[REDACTED]
Subject: RE: AL/81/19/PL - D2, Paddock View

Subject: AL/81/19/PL - D2, Paddock View

Drawing 2 / 4	
All drawings are copyright of BKM architectural plans and drawings service and may not be reproduced without prior permissions

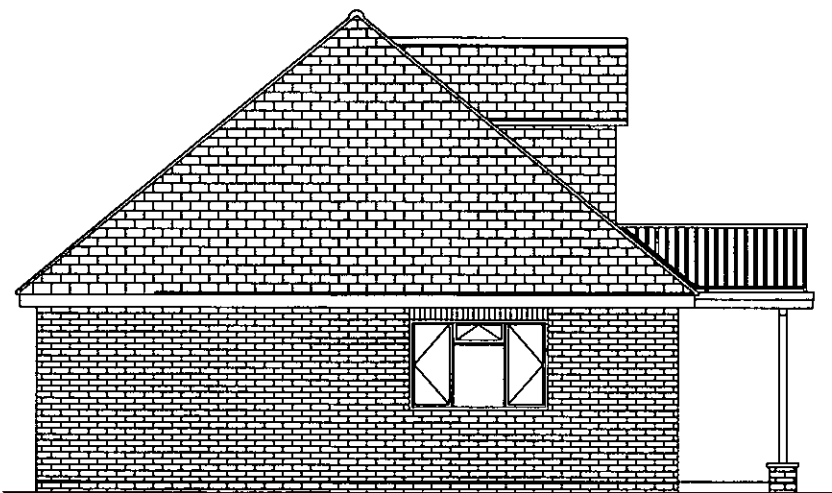
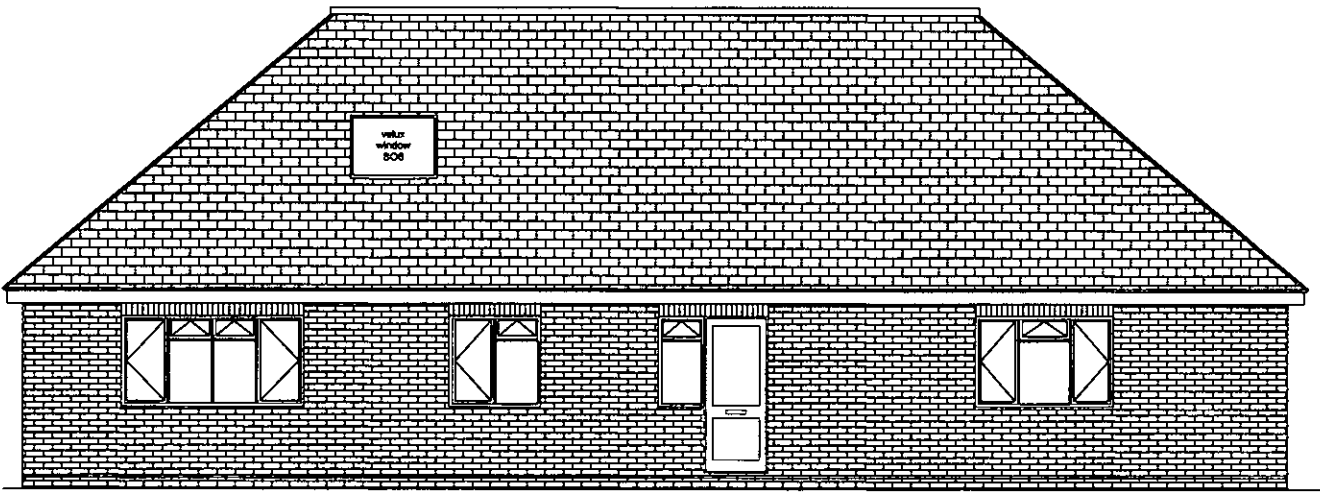
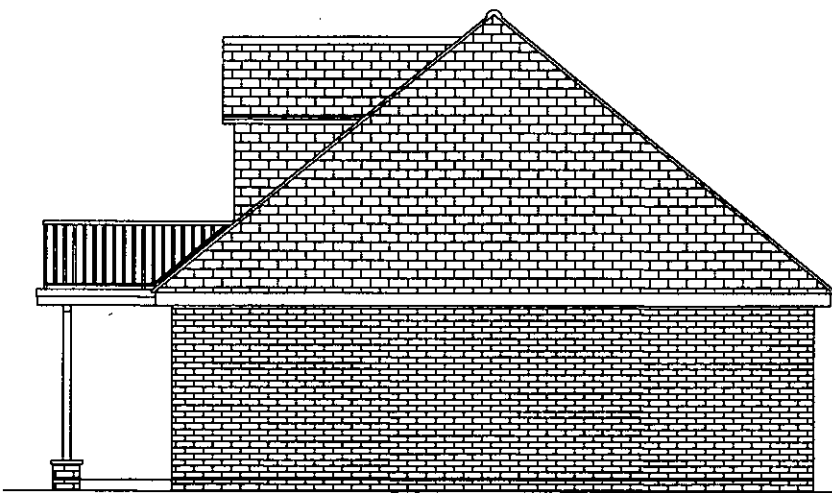
Thanks for these. However, for our purposes (the purposes of protecting the amenities of the neighbouring property), we need the sill height of the velux to be 1.7m above the floor level when measured vertically (i.e. so only those people greater than 170cm in height would be able to see out of the window. Is this possible to provide?

Can you amend the drawings to mark it as obscure glazed. Can you also ensure that the sill height is at least 1.7m and can you show this on the section drawing.

I note on the plans that a velux window is shown in the rear elevation which could potentially permit overlooking of the neighbours property. Is this window strictly necessary?

Revised plans attached showing and noting obscure glass and escape levels.

The velux window was chosen in preference to a dormer, being a bathroom it will have to have obscure glass (not noted on plan). I will have to rely on your discretion, please let me know if a revised plan is required.
